Please upload the below to the above application: Conservation Officer comments.

BE/7/21/PL

377-379 Chichester Road Bersted PO21 5AT

Demolition of outbuilding & change of use of redundant shop to 3 No. two bedroom flats, associated parking & gardens

Drawing: Proposed NE & SW elevations - (1:100@A3)

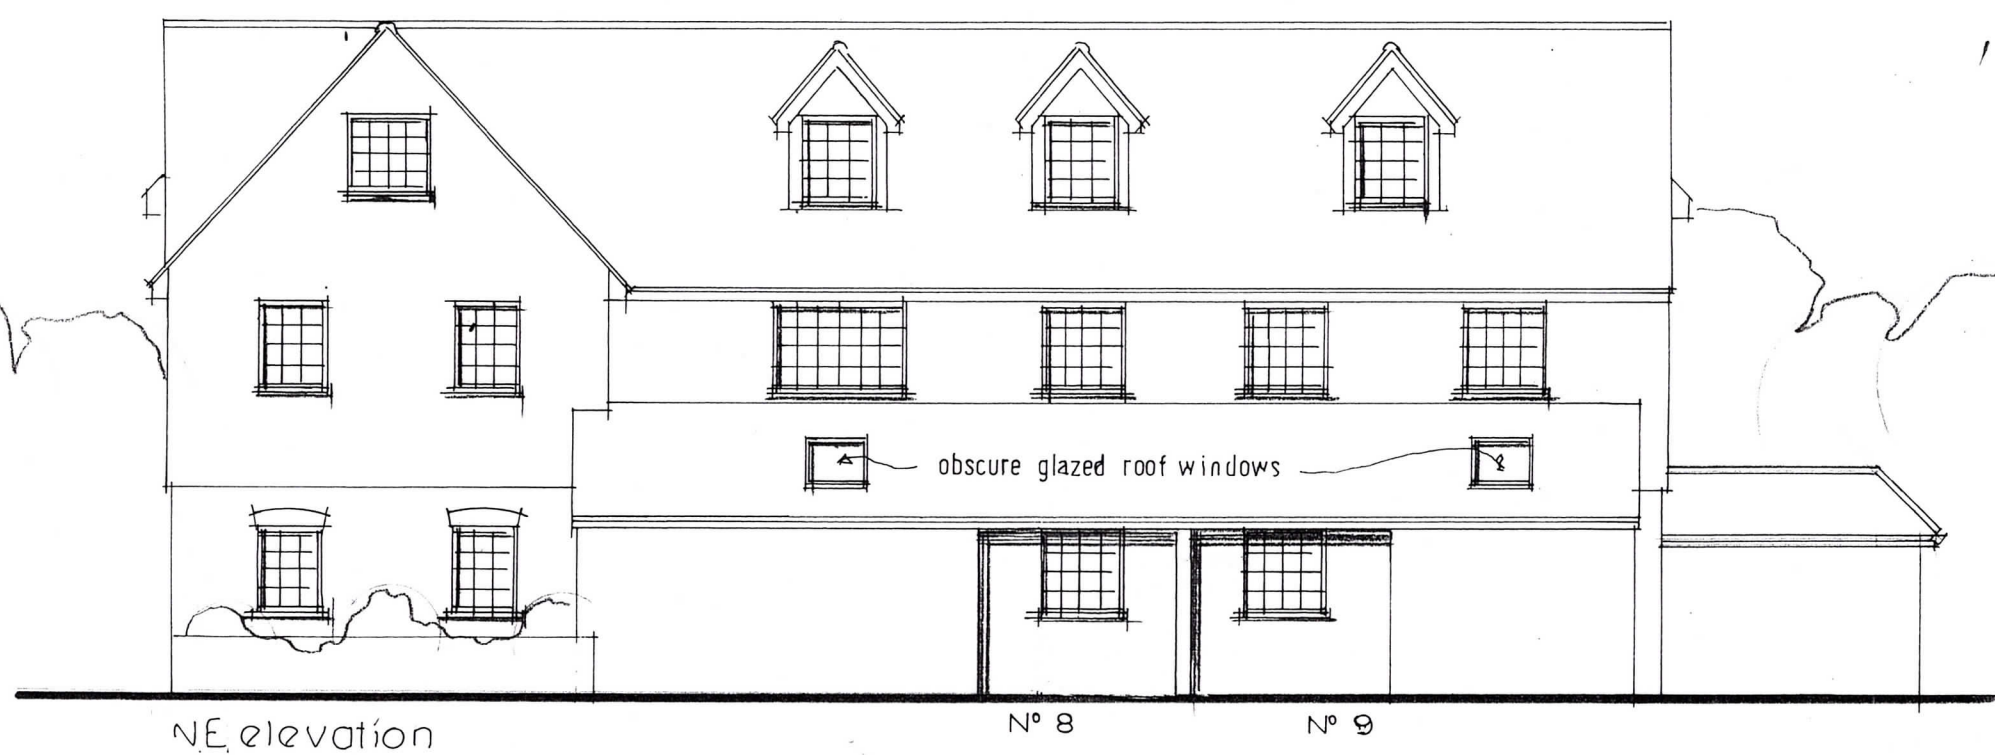
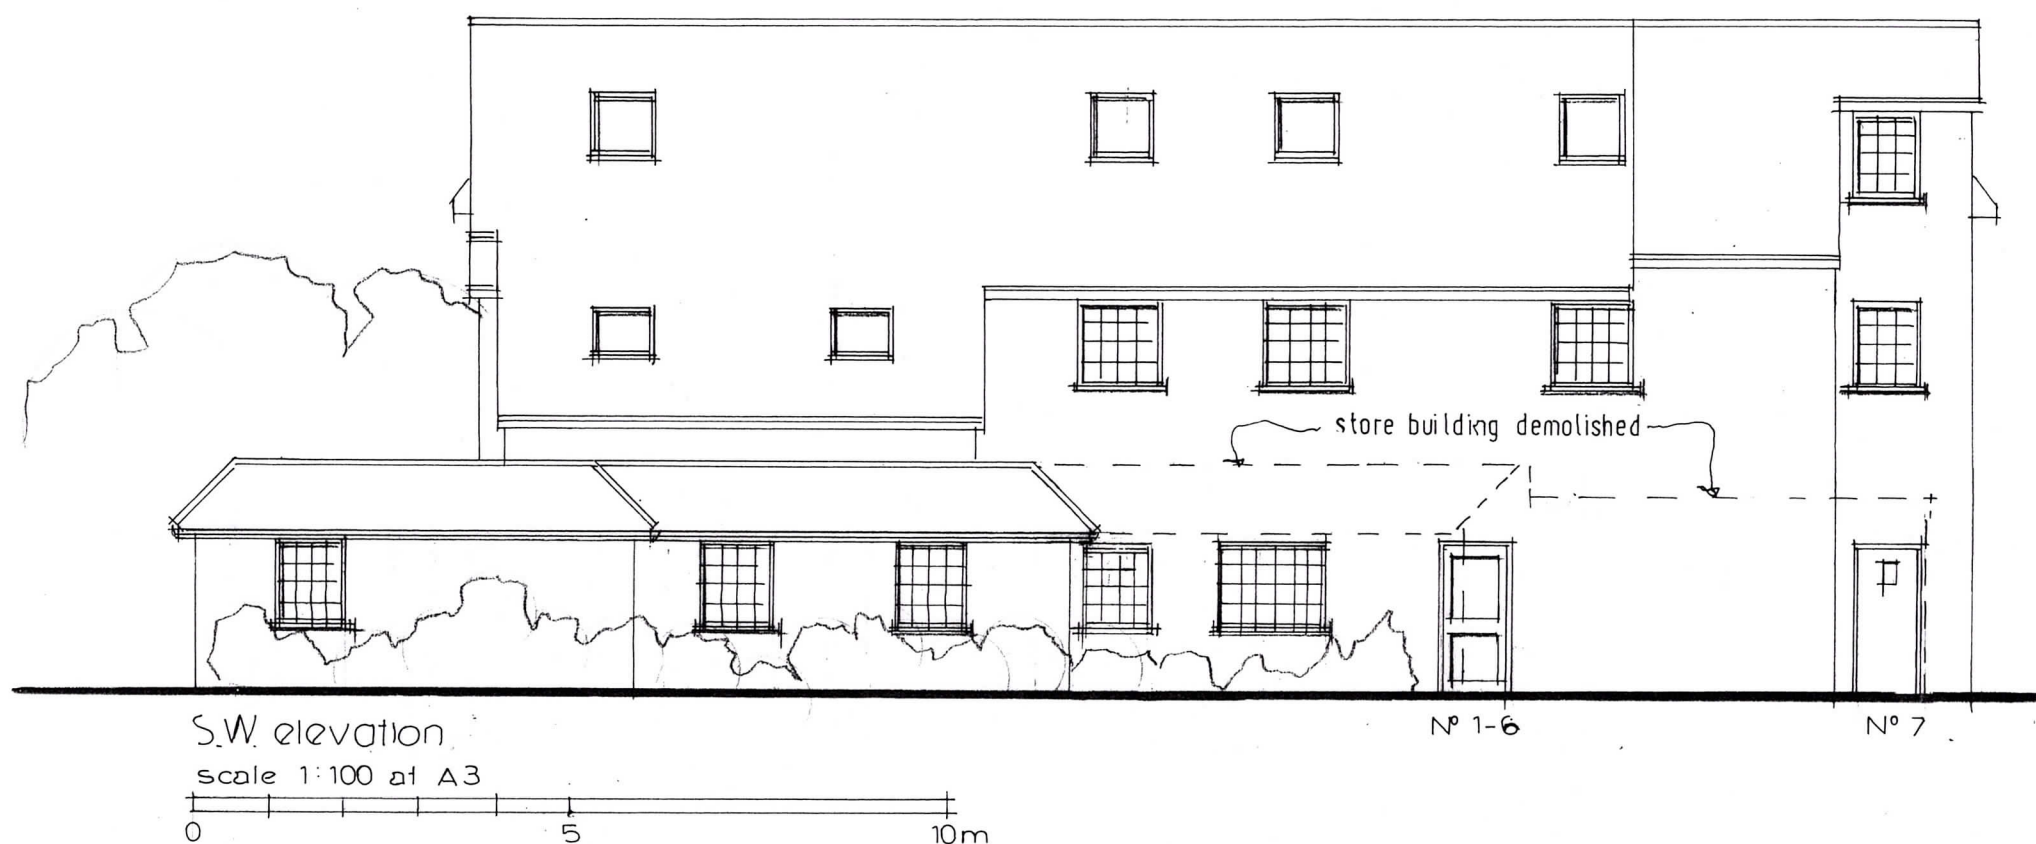
The proposals will affect the north east elevation in that the existing door will be replaced with an opening and recessed area which will accommodate the entrance for two of the apartments and two windows. This will be an improvement upon the existing ground floor elevation, and it would attempt to enhance the blank wall. The additional windows on the north-west elevation are of a scale and appearance that is also acceptable in this instance. Likewise, the use of windows and doors on the north-east elevation to match the existing ones will ensure that the impact upon the neighbouring listed buildings will remain the same.

It is noted that the proposed north east elevation will include two roof lights. It is suggested that these be of conservation standard in order to ensure a more appropriate appearance for the neighbouring listed buildings.

Drawing: Block plan as existing- (1:200@A3)

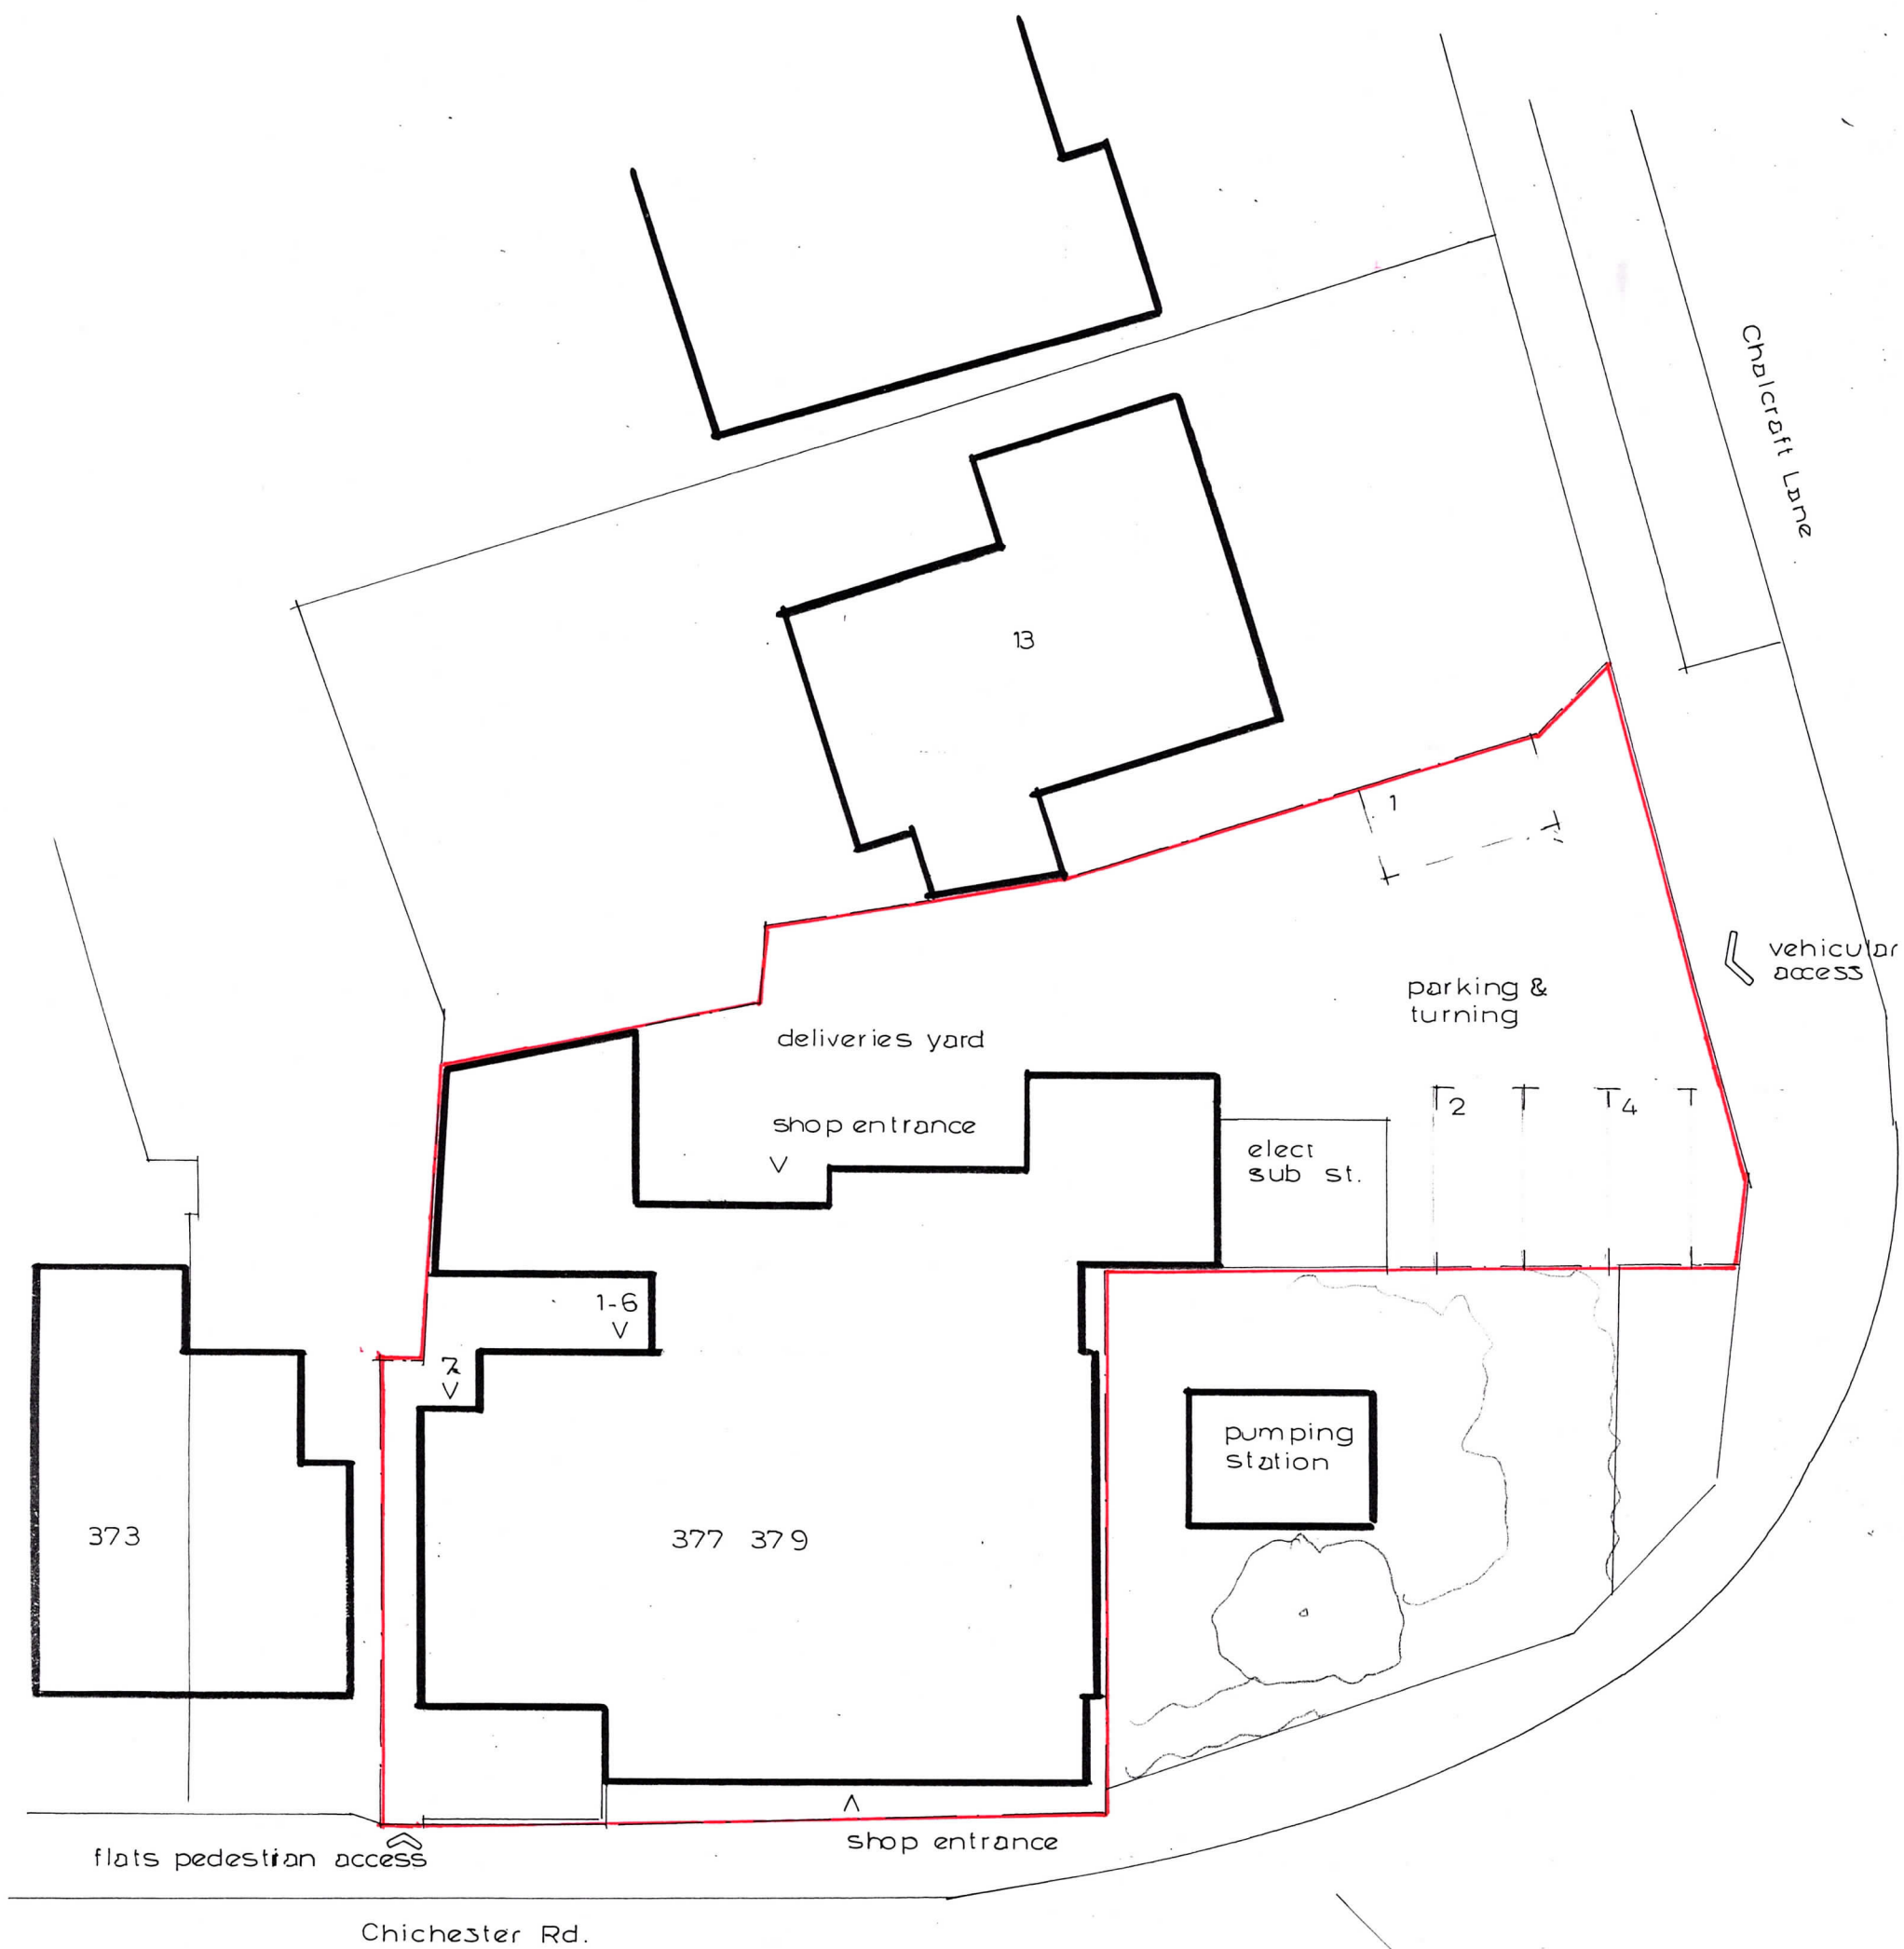
The demolition of the existing outbuildings and their replacement with a garden will remove an element of the modern building which is located close to the neighbouring heritage assets. This will result in the loss of an unattractive element and enable the rear elevation of the listed building to be better appreciated.
